Application No:	H02-0189-23	Applicant:	Mr T Arlow
Proposal:	Proposed Dwelling (Plot 1) - outline approval H02-0564-22		
Location:	Plot 1 Adj. 17 Barbers Drove Crowland		
Terminal Date:	28th April 2023

CASE OFFICER ASSESSMENT

PROPOSED FIRST FLOOR PLAN

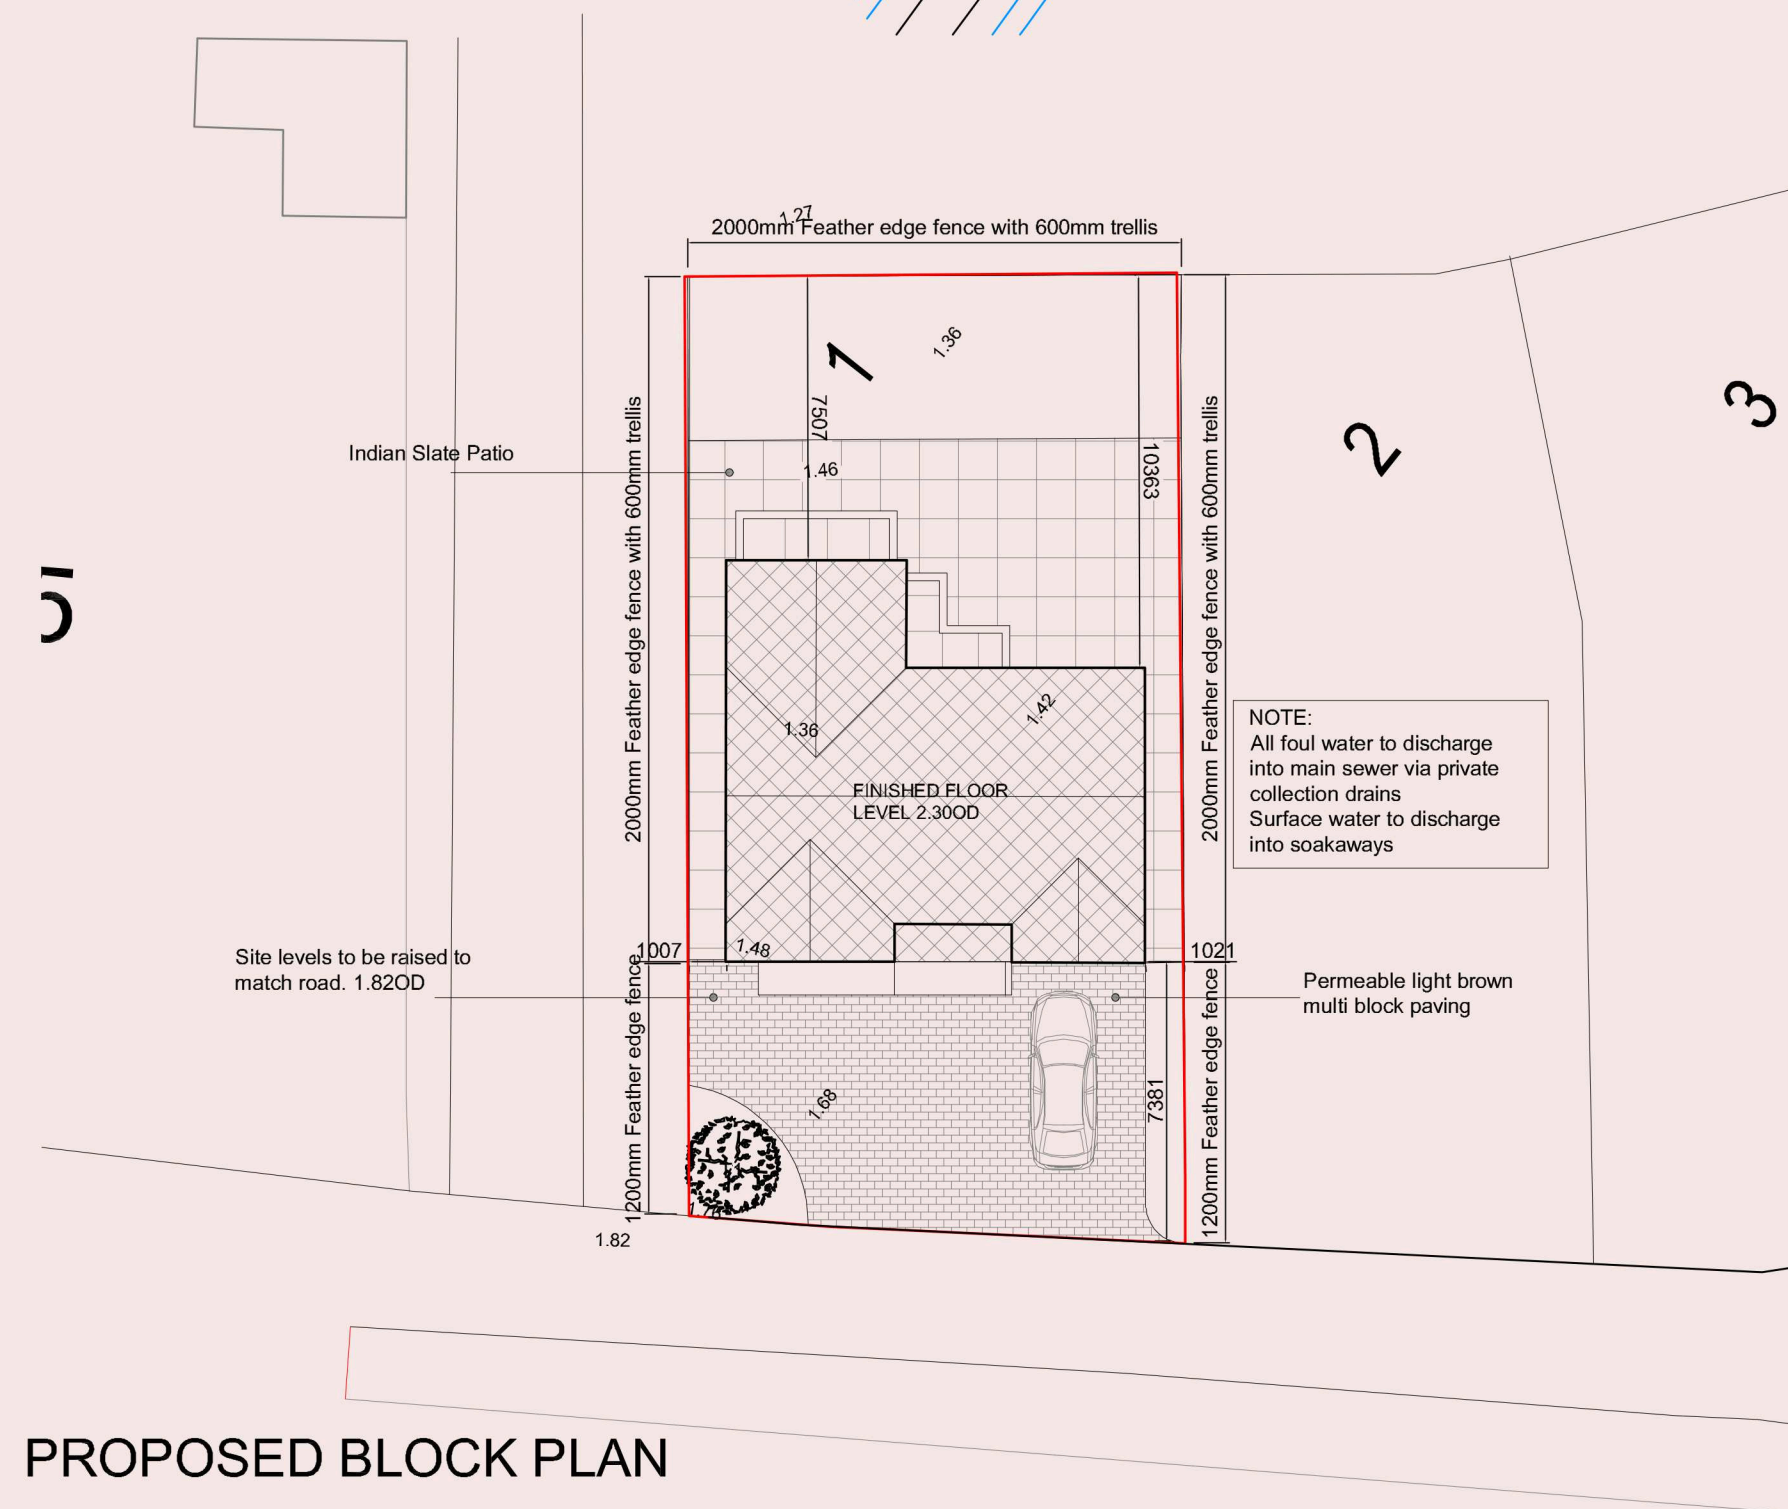
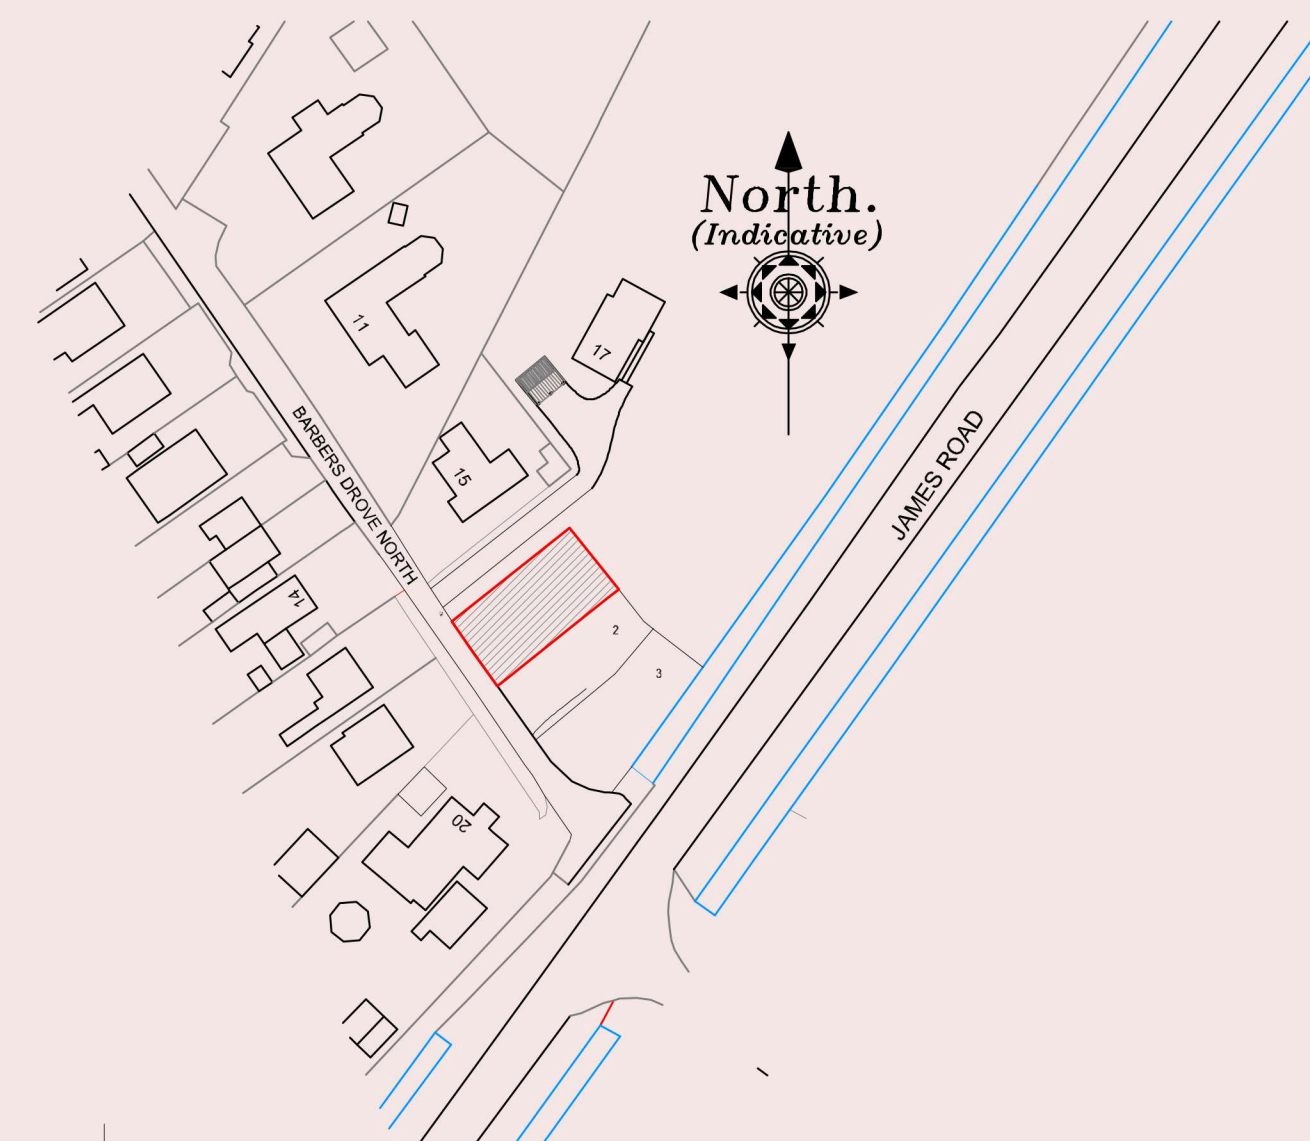
The block plan shows one dwelling sitting adjacent to number 15 Barbers Drove North, which is set north west of the application site. Number 15 has an access road to a garage adjacent to its boundary. Google Earth indicates the width of this access to be approximately 3 metres. An existing access road exists close to the boundary with number 15 (separated by grass at present) linking to 17 Barber's Drove North at the rear, which is being retained, but the access itself will need to be reconfigured for the redevelopment of the larger site behind. On the outline block plan for the 3 houses under reference H02-0563-22, the access to 17 Barber's Grove is shown almost directly next to number 15's flank boundary wall, with a further 3m access as required by H02-0064-21 adjacent to it. The flank wall of the application premises is set next to this required access. The proposed dwelling is set in 1m from the flank boundary of the plot.

The distance between the flank wall of number 15 Barbers Drove and the proposed dwelling is estimated to be approximately 11 metres (estimated to be 3 metres for number 15's drive to its garage; 4 metres for the reconfigured access for number 17; 3 metres for the required access as part of H02/0064/21 and a set in of 1 metre from the boundary of the application plot to the flank wall of the proposed dwelling). Given these distances, it is not considered that there would be loss of light, nor is it considered that the proposals would be overbearing on number 15. Whilst there would be a change to the view and outlook of number 15 from the 4 windows cited in the objection,

it is not considered that loss of view or outlook would be so severe as to justify refusal due to the separation distances mentioned above. However, in order to protect privacy a condition is suggested restricting further flank windows or other openings on the dwelling, and to ensure the first floor flank window is finished and maintained in obscured glass.

Two gables form the main feature of the front elevation, with finished floor levels set to 2.3 OD. Site levels are to be raised very slightly from existing ground level to match the road which is 1.82 OD. The design incorporates a rear projecting gable with indian slate patio and rear garden laid to lawn and landscaping. The rear garden is between 7.5 and 10 metres which is considered satisfactory for a modern development.

The dwelling would be approximately 8.3m to the top of the ridge, 7.3m to the top of the largest gable, 5.3m to the top of the eaves and 11m wide. The flank of the proposed dwelling would be approximately 11m from the flank wall of number 15 Barbers Drove when measured on the Block Plan.

However, the storey height on this plot was not restricted to bungalows in the outline consent, the layout does allow a small set in of one metre each side, and whilst set forward of number 15, there is an estimated separation distance of 11 metres from this property and the application property, and the proposed dwelling has a 7.4m driveway, setting it back from the road. These factors will reduce its prominence. It is not considered that refusal of planning permission due to its impact upon the street scene would be justified. The scale is not considered to adversely affect the street scene to such an extent that it would be contrary to policies 2 and 3 of the SELLP.
